SUBJECT: Engineering Review Comment  
Mountain View Electric Association Inc. (The Association)

**Project Name: Crowe Minor Subdivision**

**Project Number: MS215**

**Description:** Proposed development of 3 single family lots on approximately 20 acres located at 15980 Roller Coaster Rd. in Township 11, Range 66, Section 28.

MINOR SUBDIVISION PLAT  
CROWE SUBDIVISION FILING NO. 1

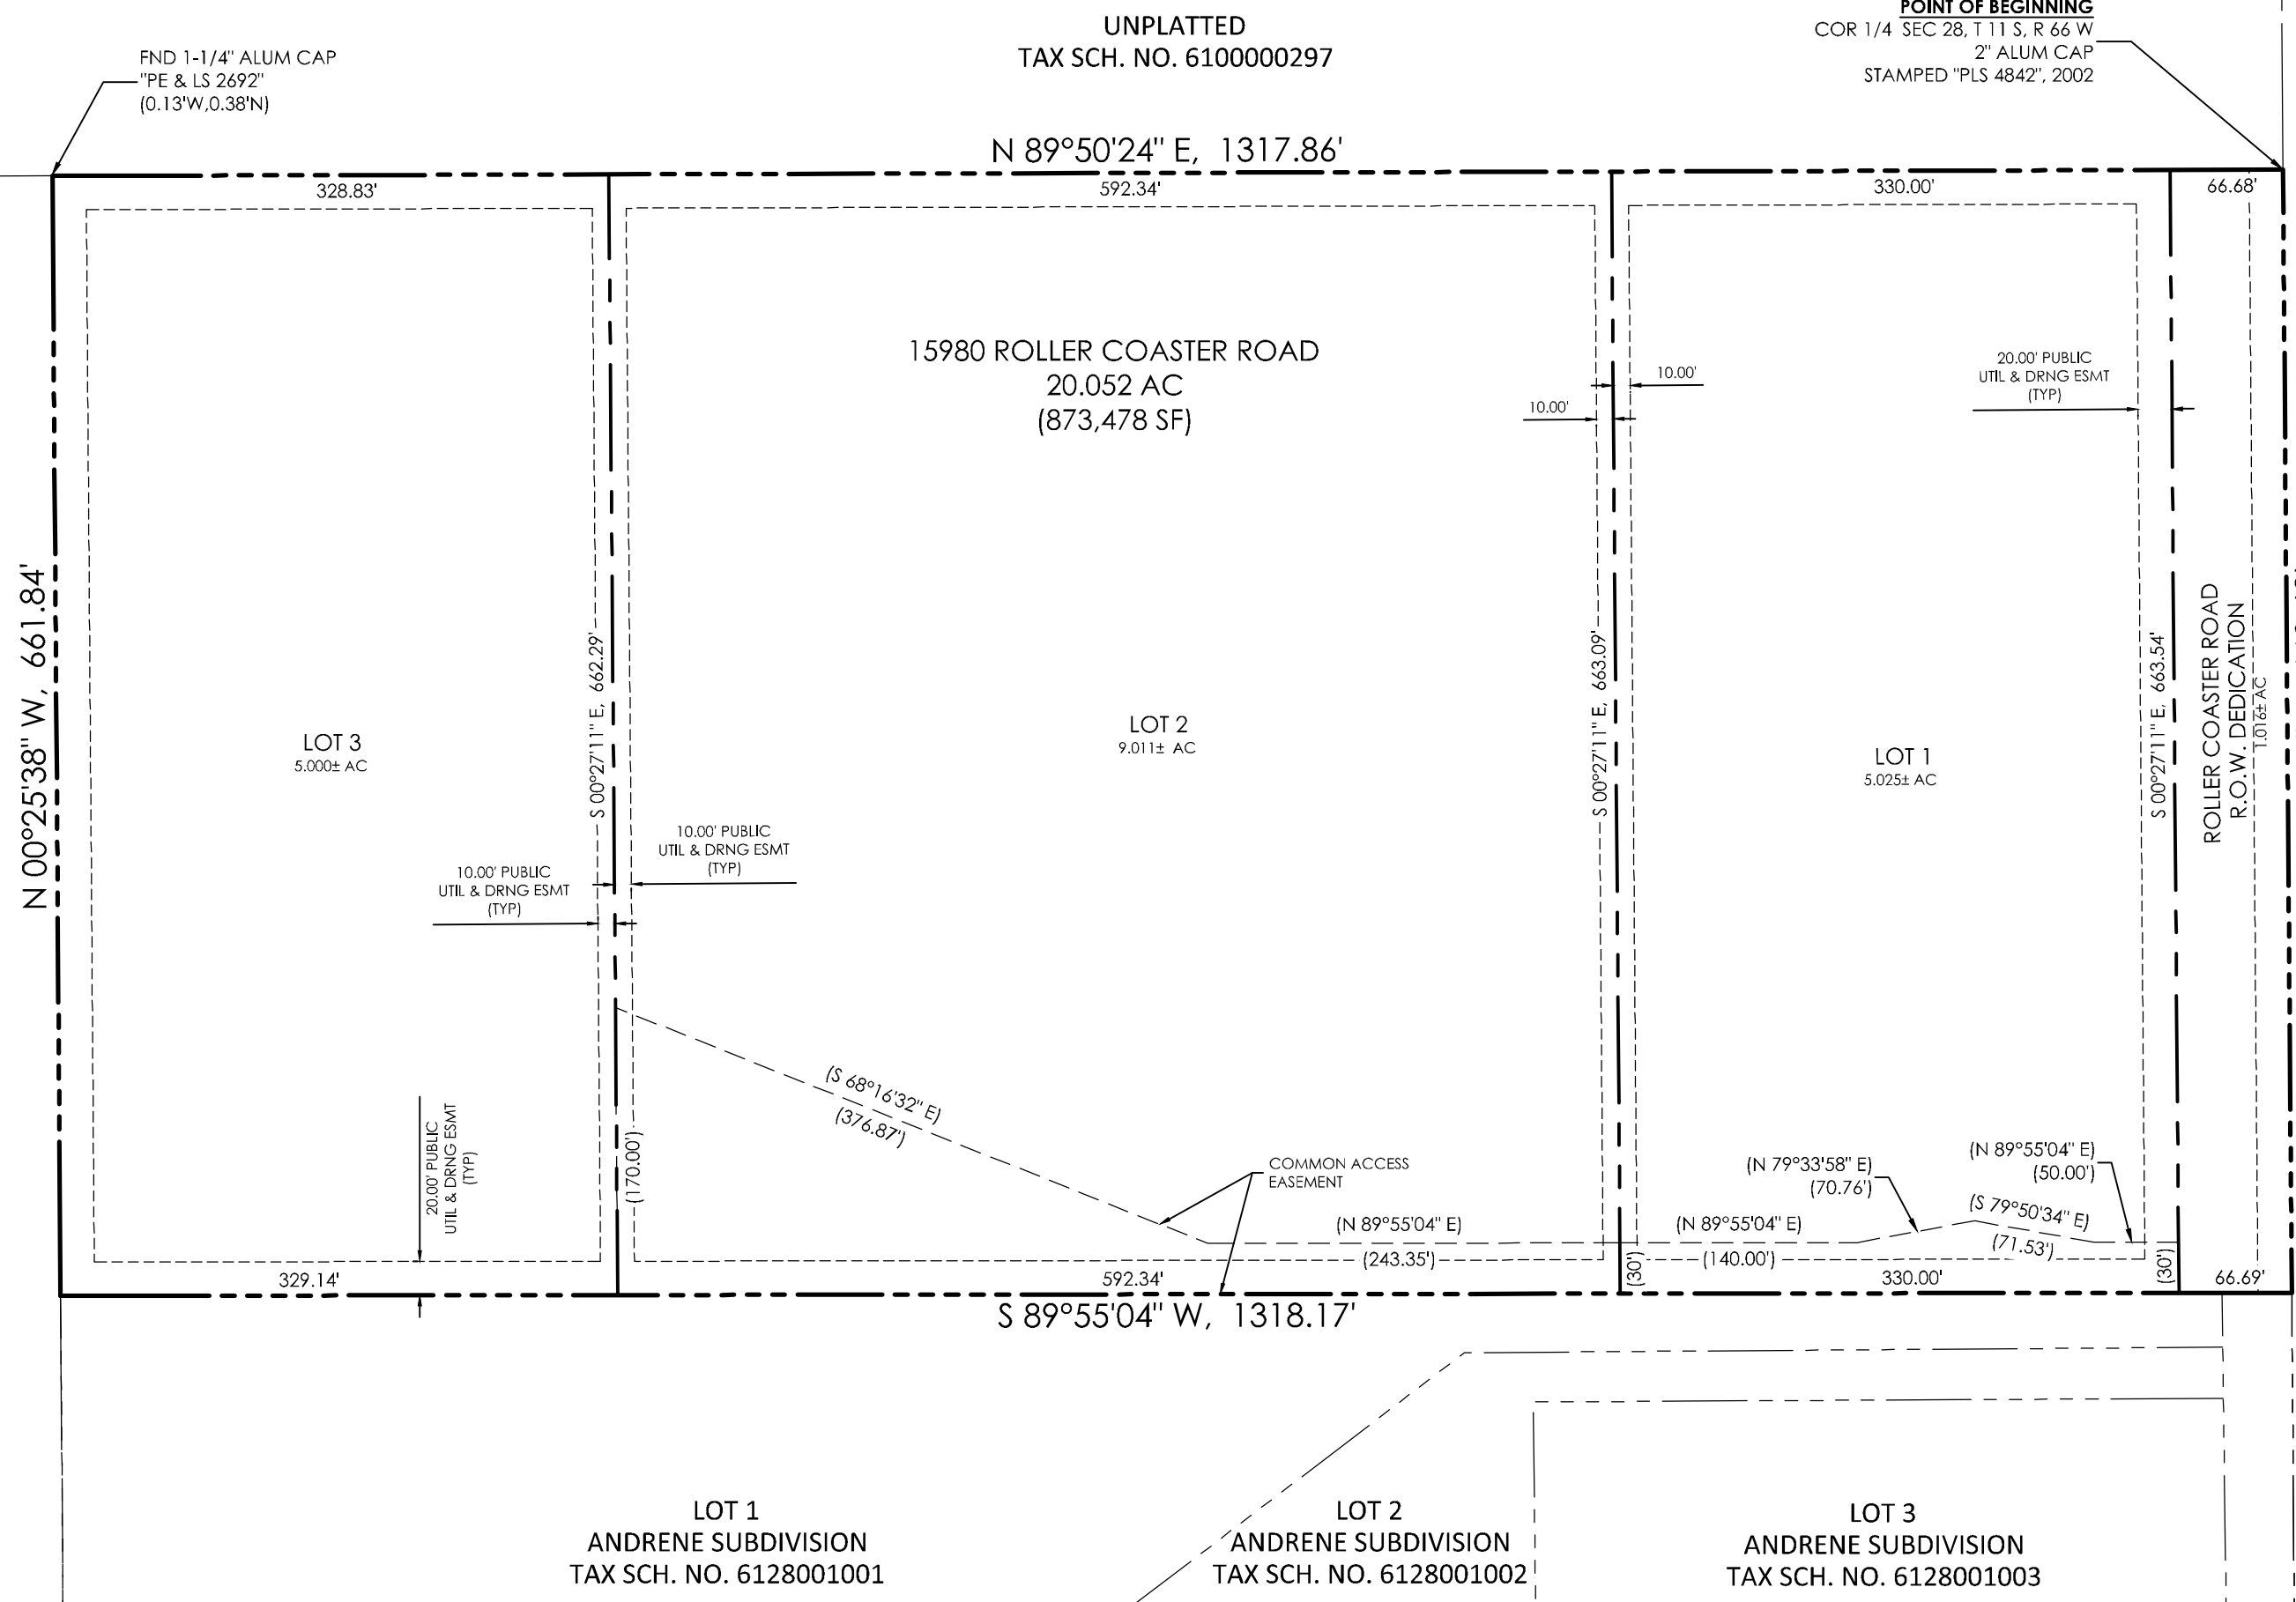
The Association requests a ten (10) foot front, side, and rear lot utility easement and all tracts, along with a twenty (20) foot exterior utility easement on the plat. The Association also requests the platting of the Association's existing facilities with easements on the plat. Additional easements may be required.
